### **SUBMISSION REPORT**

### **M2 SITE WITHIN THE NORTH RYDE STATION URBAN ACTIVATION PRECINCT (SSD 5093)**

I am writing in reply to your request for comment regarding the Response to Submissions and additional information received by the Environment Protection Authority (EPA) on 21 November 2014.

Figure 6.1 – Music Treatment Train Diagram

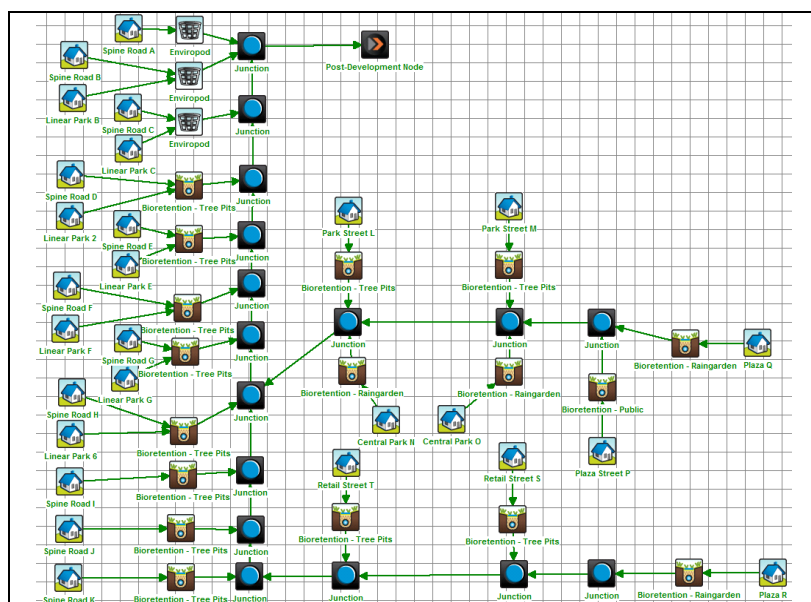
In response to comments on water quality detailed in the EPA's letter dated 23 September 2012, the proponent states that the stormwater management submitted with the State Significant Development application plan addresses the EPA comments. While the plan did provide an assessment of residual pollutant loads against Ryde City Council Development Control Plan (DCP) criteria, it did not include an assessment of impact that any proposed discharges (construction and post construction) will have on the receiving environment. In particular, whether the water discharged from the site will not adversely impact watercourses such as Porters Creek and Lane Cove River. Such an assessment was also a Director General Requirement. The EPA also identified a range of other matters in its response which have also not been fully addressed to date.

In addition, the proposal involved a treatment train approach for the management of stormwater that will require regular and ongoing maintenance to ensure performance. The EPA recommended that information be sought from the proponent on who would be responsible for the management of these features and also the funding arrangements for their ongoing management. The Submissions Report did indicate that stormwater was a consideration as part of the Voluntarily Planning Agreements (VPA). It is unclear from the Submissions Report, however, whether the VPA has addressed this issue. In addition, it is still unclear who and how management of the stormwater features will be undertaken post development.
